CITY OF ALBUQUERQUE

June 28, 2018

RE: **Nuevo Atrisco
Central and Unser NW
Conceptual Grading and Drainage Plan
Plan Date: 6/18/18
Hydrology File: K10D058**

**CONCEPTUAL
GRADING AND
DRAINAGE PLAN
1 OF 2**

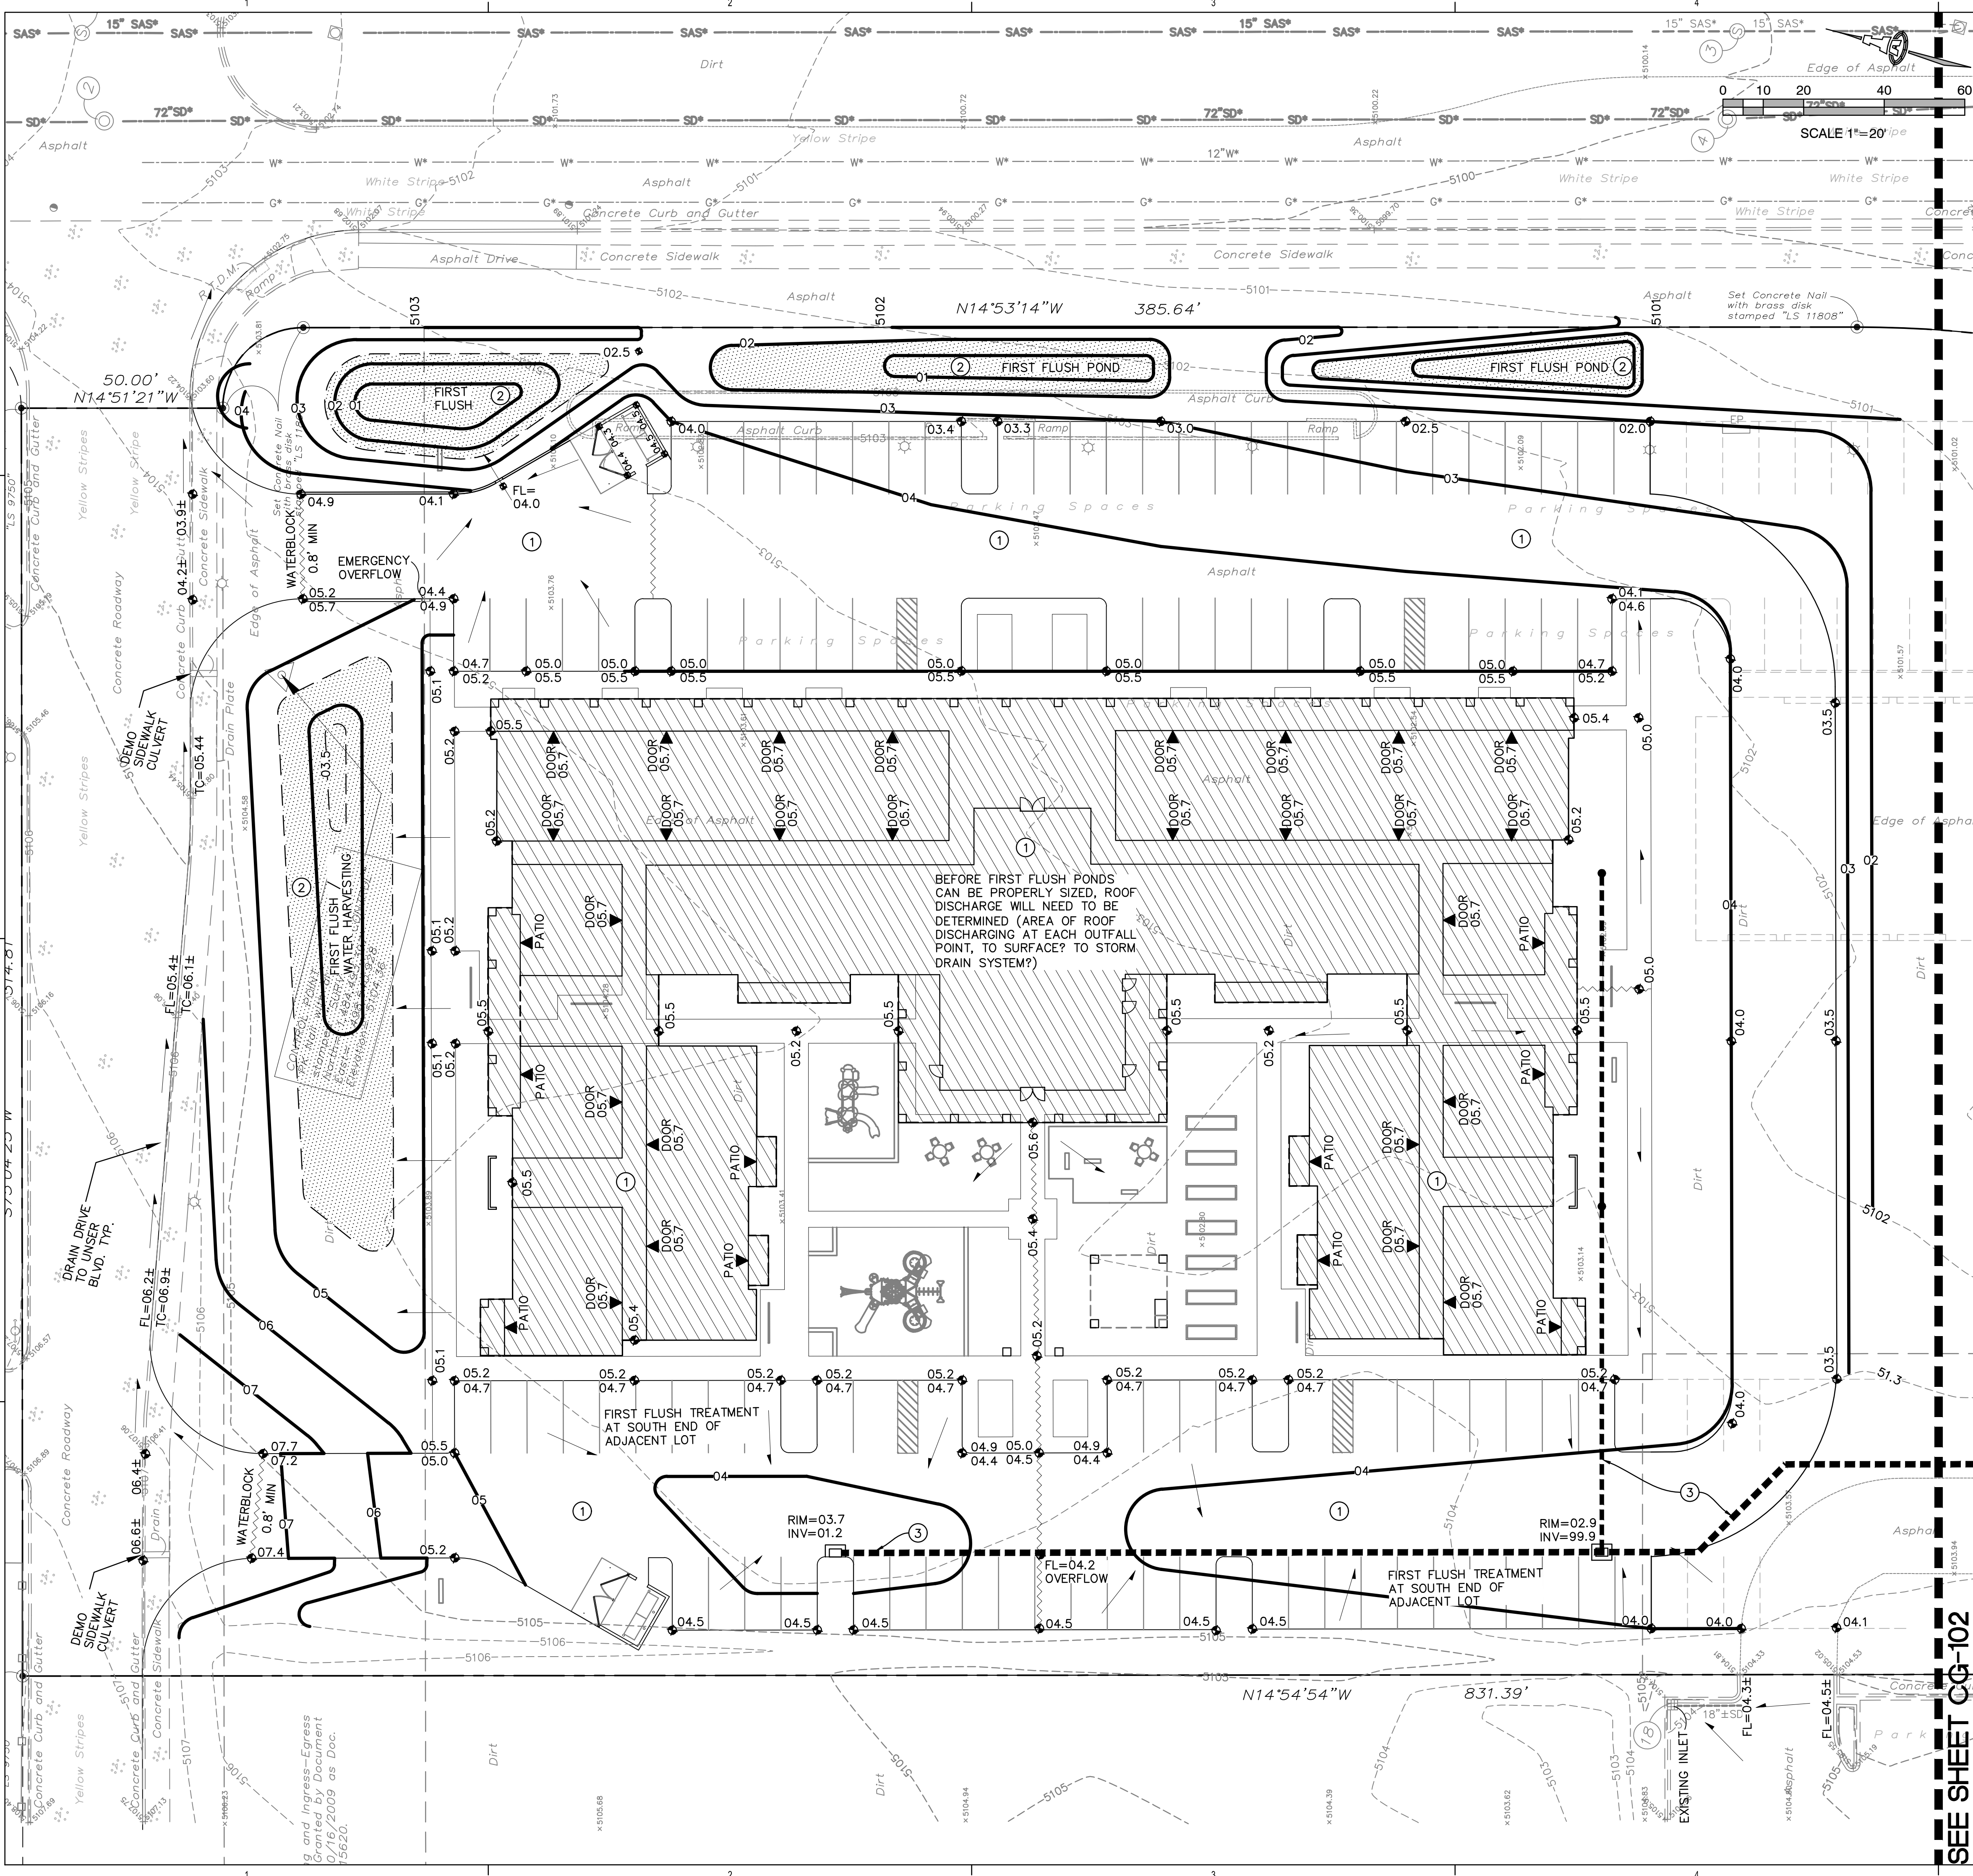
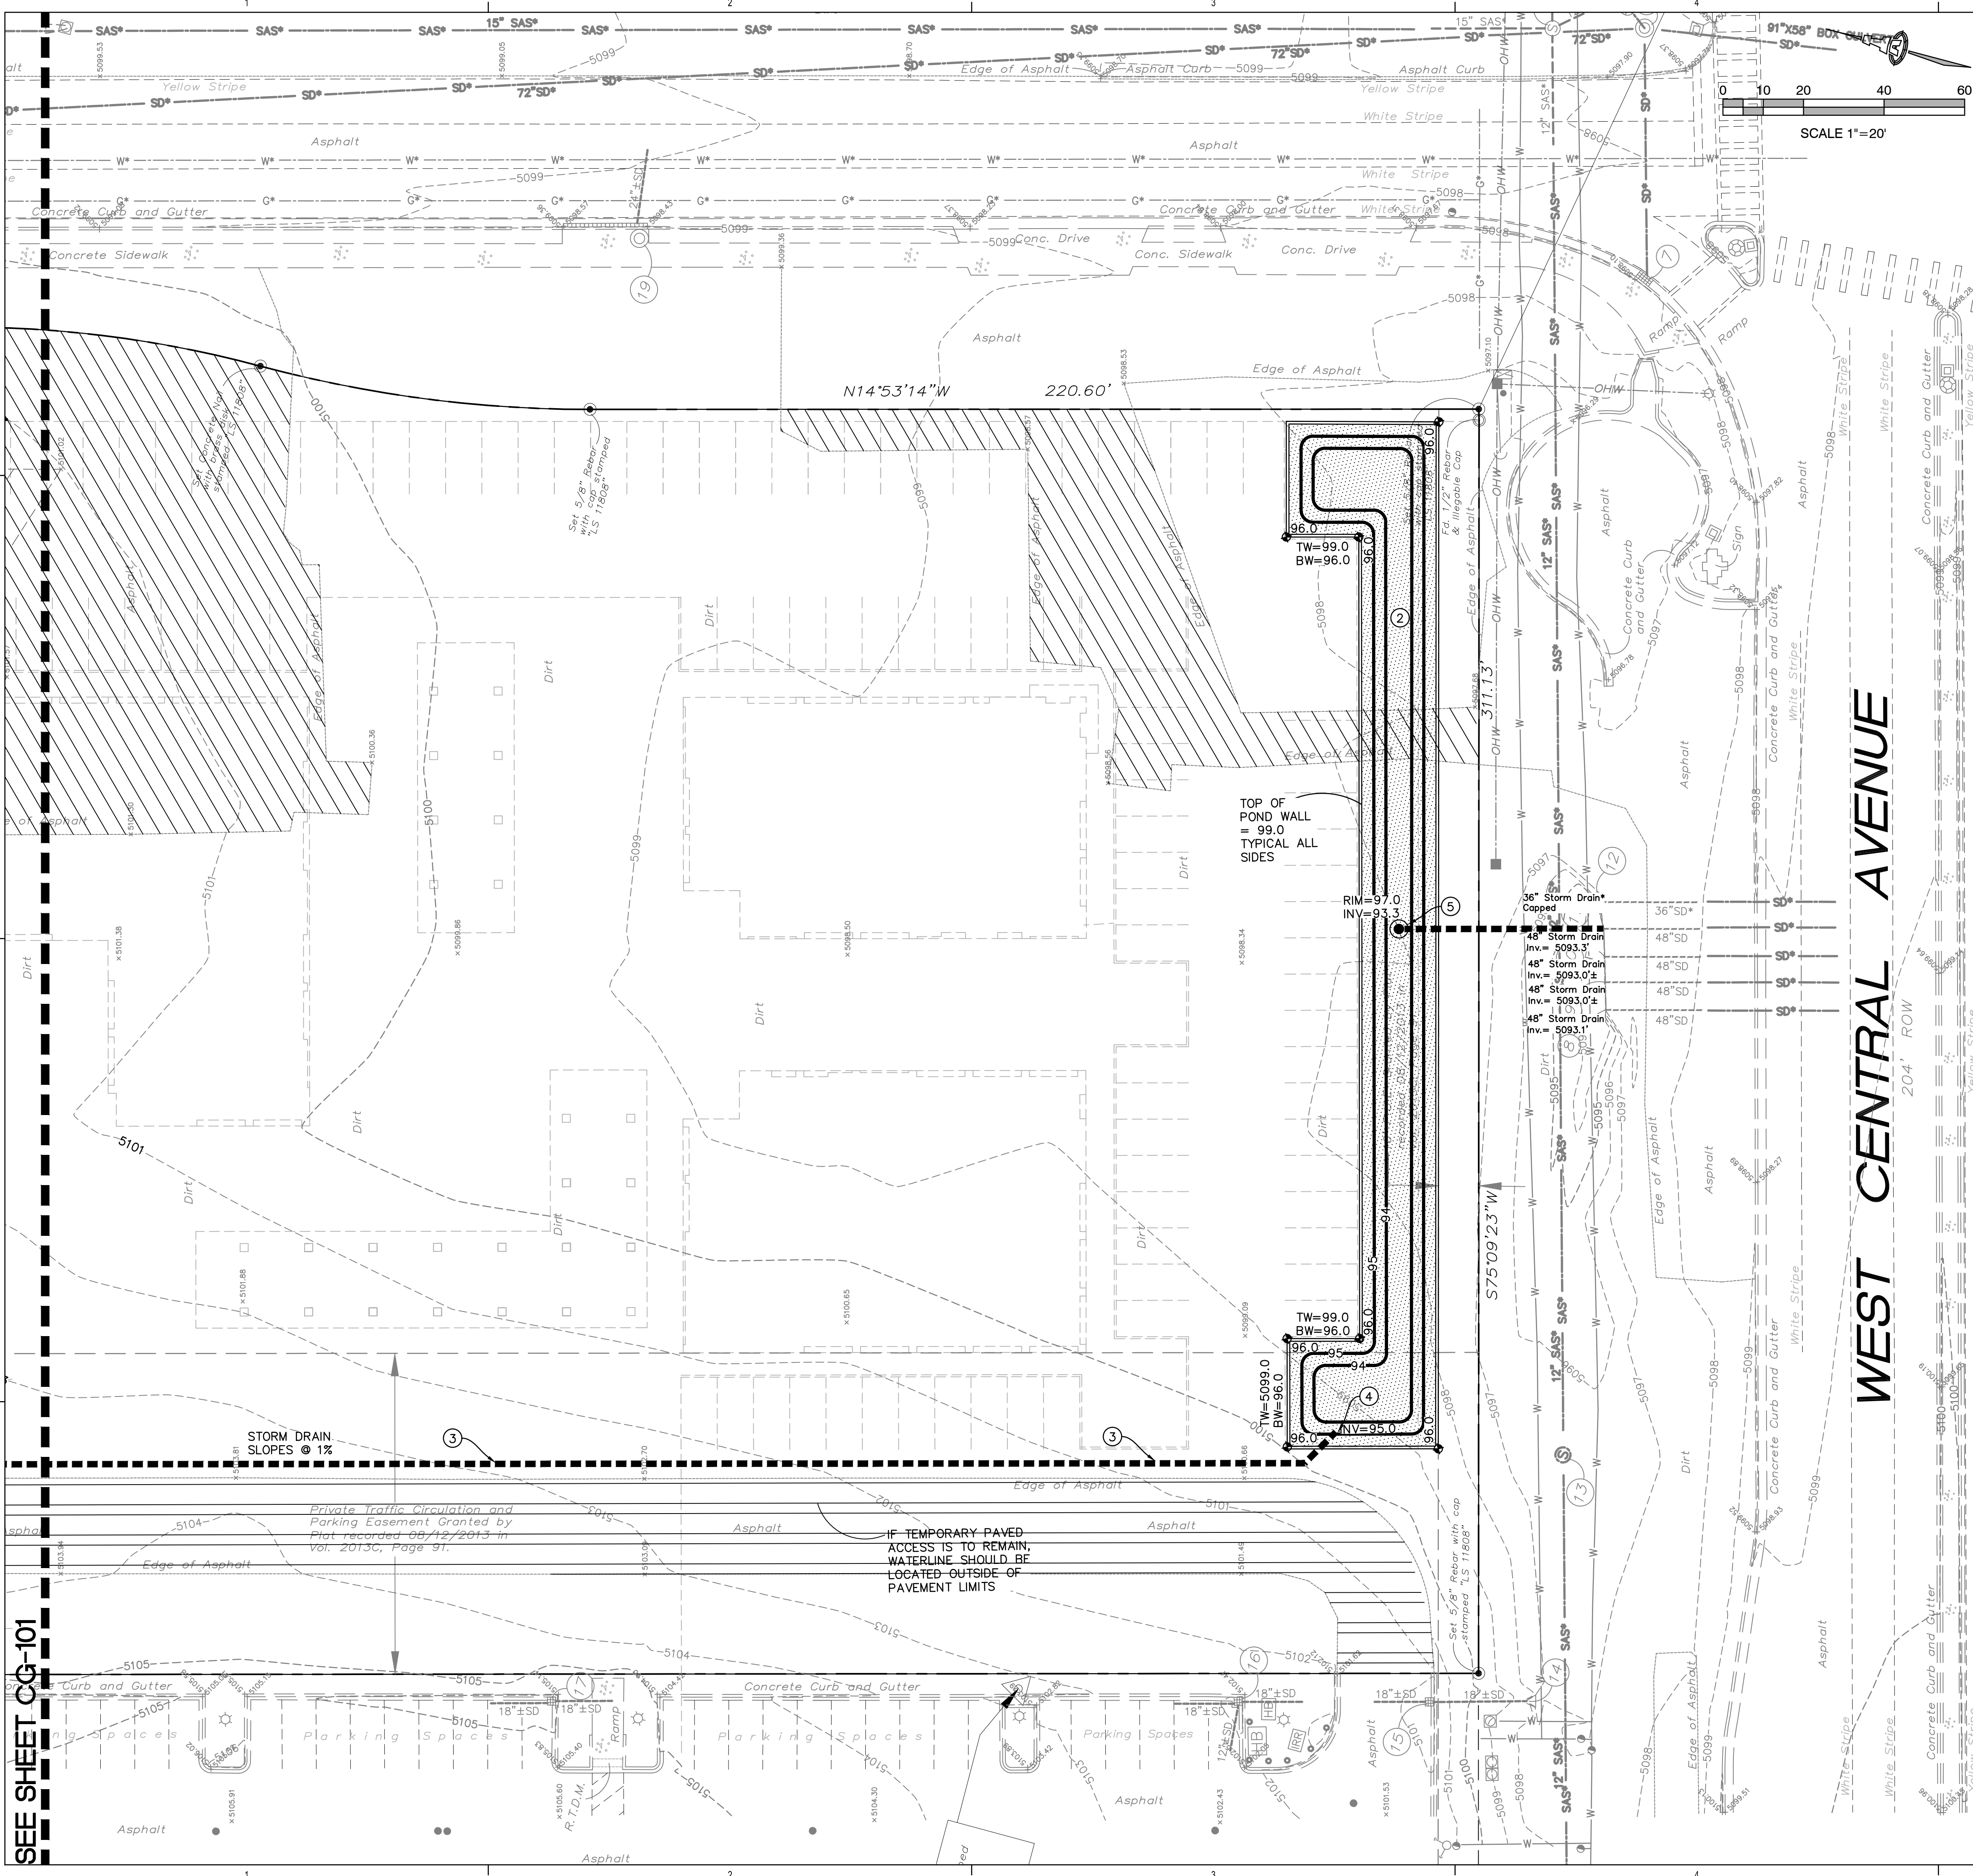
1. The Drainage Report will need to be stamped and signed by the Engineer; calculations will need to be re-verified with respect to the final site layout, especially the 80% impervious assumption.

2. The final constructed southern pond (Req'd Volume=5480cf) may be deferred to the Tract B development. But enough of the pond volume will need to be constructed to serve the first flush requirement for Tract A, as well as keep sediment from washing into the storm drain. A drainage covenant on Tract B will be required for the temporary pond (and the final pond, once built).

5. Subbasins will need to be delineated for each first flush pond and each pond sized for the area draining to it. Roof runoff needs to be routed to the ponds once the site layout is finalized.
